PLANNING APPLICATION REPORT

REF NO: LU/247/09/

LOCATION: Littlehampton Promenade
Littlehampton

PROPOSAL: Removal of existing benches and shelters on seafront promenade. Replacement with single bench structure from east Beach cafe to rear of concessions adjacent to Harbour Park (sited along southern boundary with existing dwarf wall). Erection of two new public shelter structures

Bench, Movement around
Lampposts and Bins

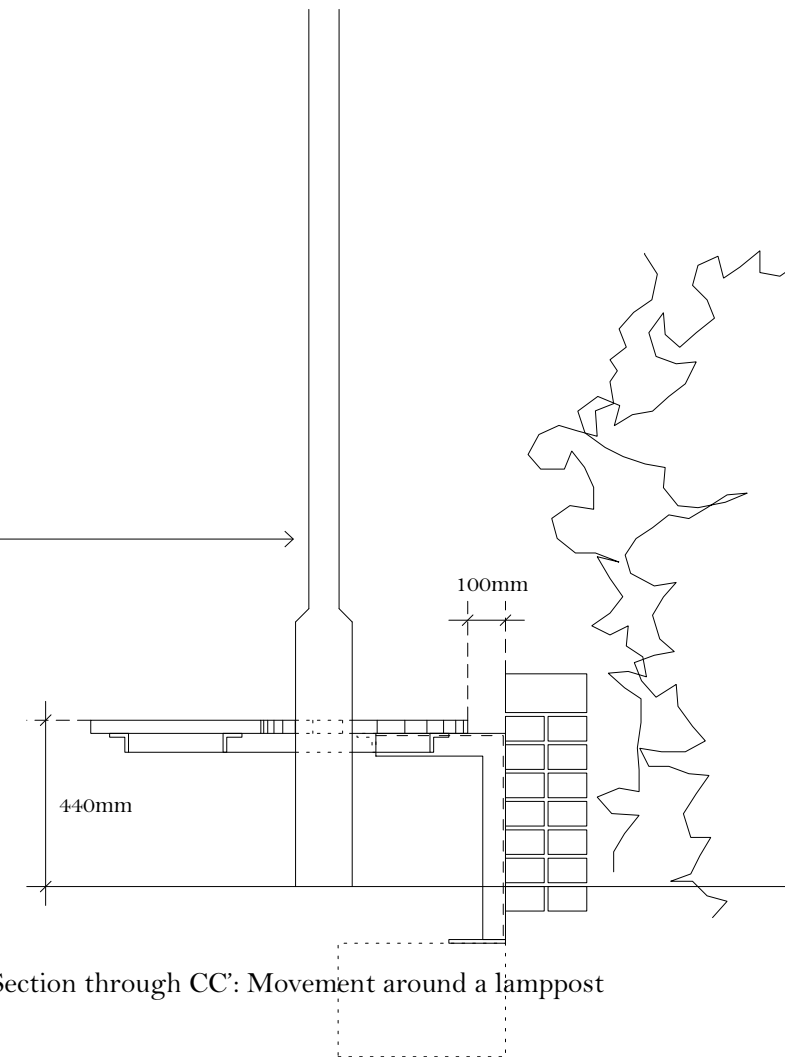
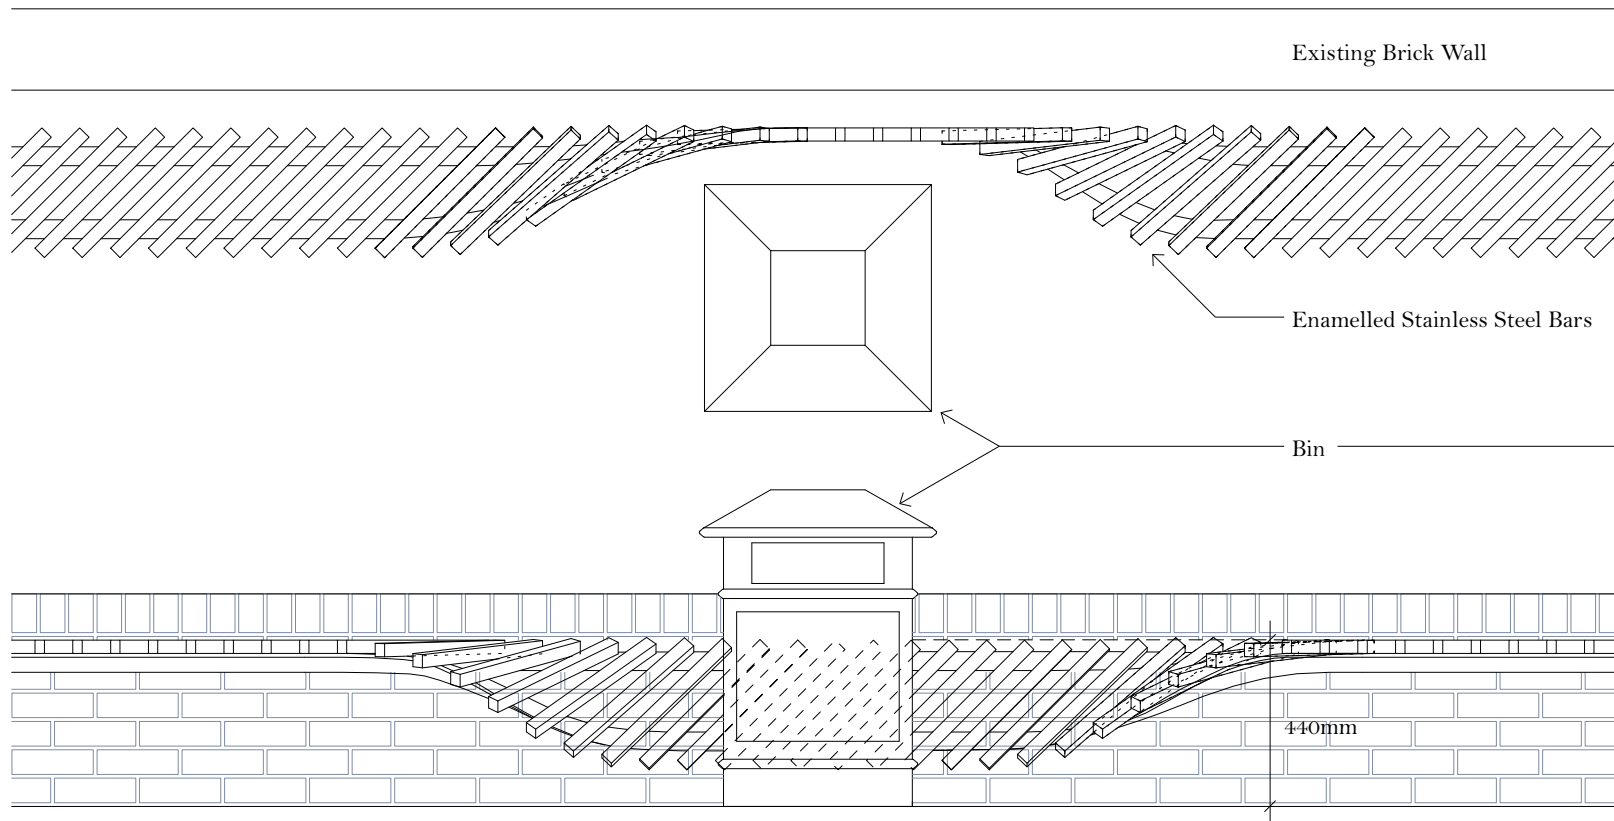
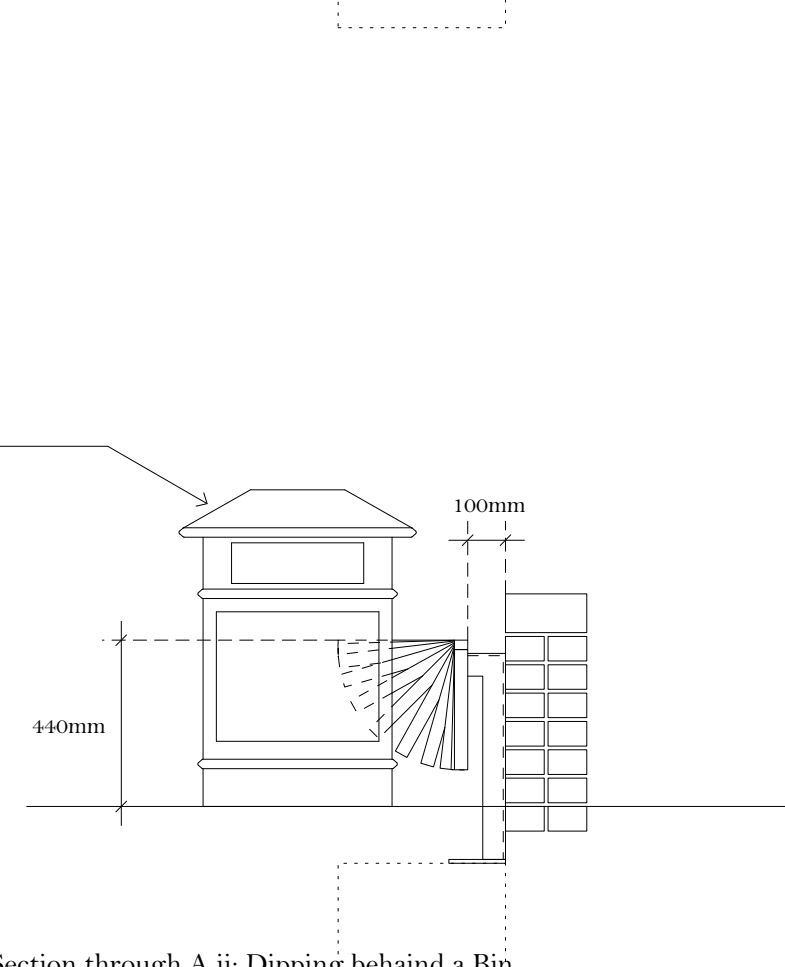
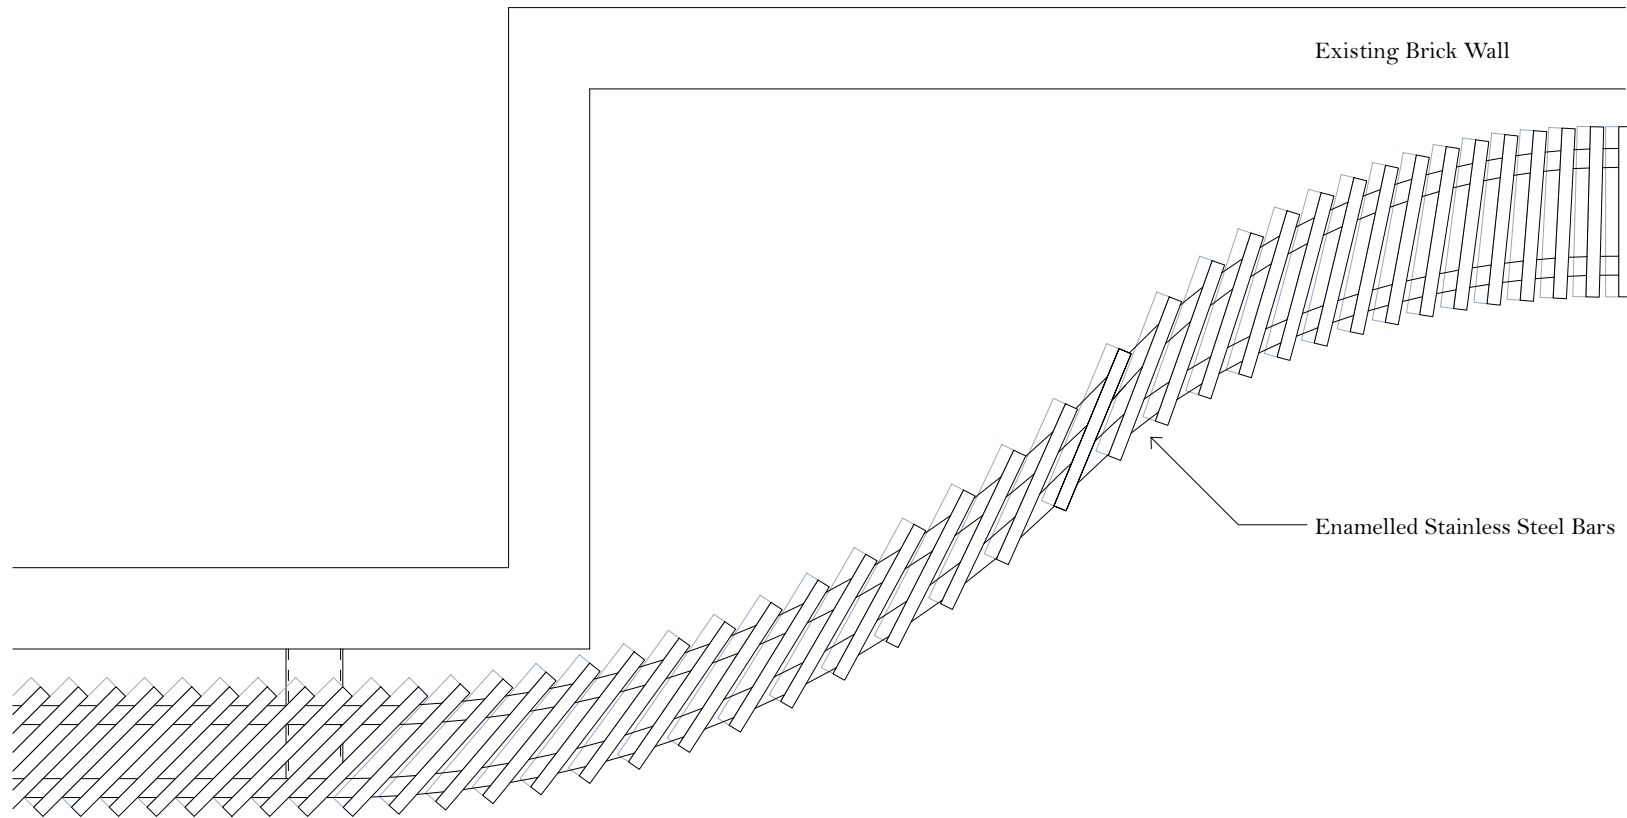
Environmental Amenities: Glad that bench runs behind the bins. It may not be possible to use mechanical sweeper once bench is in place, which means it may not be possible to have the area cleaned by 8am.

- 9 Arun District Council bins
- 11 lamp stands
- 4 flag poles
- 9 openings to the beach green and car parks
- 6 set back areas (approximately 5.5m in width) with existing benches

The bench will roll behind the existing bins and go around the front of the existing lamp stands. In the areas of existing openings, the bench will be dropped to go into the pedestrian surface in a variety of designs.

Proposed Shelter,
3D View

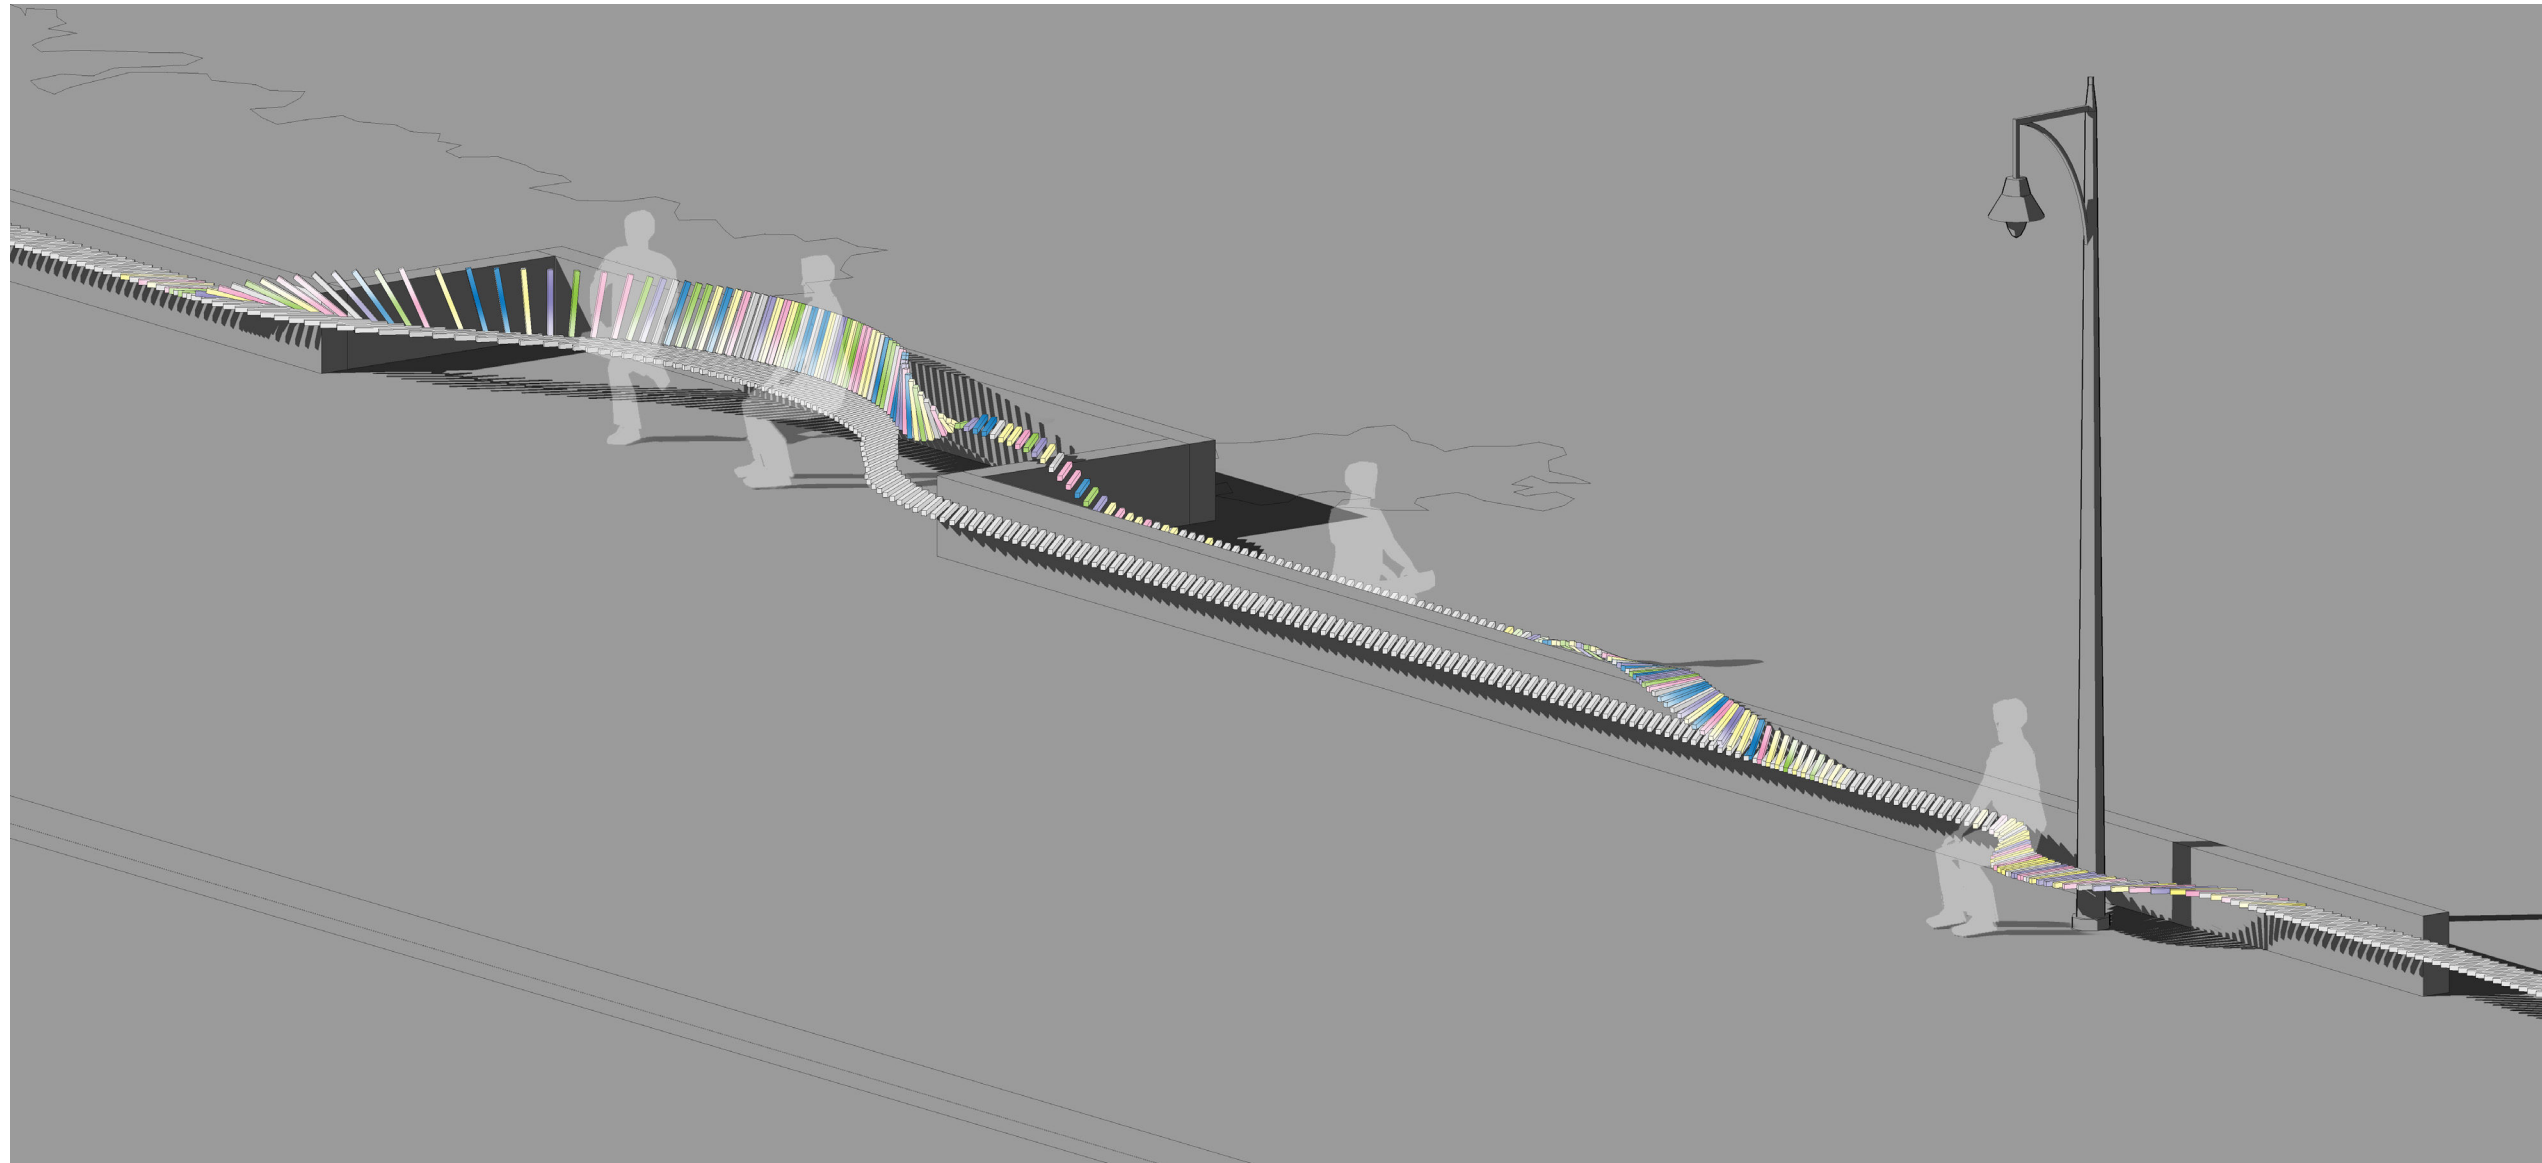
The two existing public shelters are proposed to be replaced by open shelters with the bench twisting and looping within. The shelters will be 13.7m in width x 4.4m in depth x 3.6m in height and are sited at a slight angle to provide shelter from the prevailing south west winds. The shelters will be constructed of stainless steel and be clad in metal panels. It is suggested that the finish would be a brass/bronze colour.

The two existing public shelters are proposed to be replaced by open shelters with the bench twisting and looping within. The structures will be 13.7m in width x 4.4m in depth x 3.6m in height and are sited at a slight angle to provide shelter from the prevailing south west winds and the gaps between the bars of the bench in the shelters are reduced to not only prevent climbing but also provide secondary wind breaks in the shelters.

The shelters will be constructed of stainless steel and be clad in metal panels. It is proposed that the finish would be a brass/bronze colour. The floor areas of the structures will be soft (as in playground construction) and the Council's Parks and Green Spaces Officer has confirmed that this material performs very well in terms of wearing and colour retention. A trim will be embedded into the promenade to delineate the looped shape.

- 3 Prior to the commencement of development, details of the colour of the metal panels to clad the shelters shall be submitted to, and approved in writing by, the local planning authority prior to the commencement of development. The approved coloured materials shall thereafter be used in the construction of the shelters and be permanently maintained in those materials.
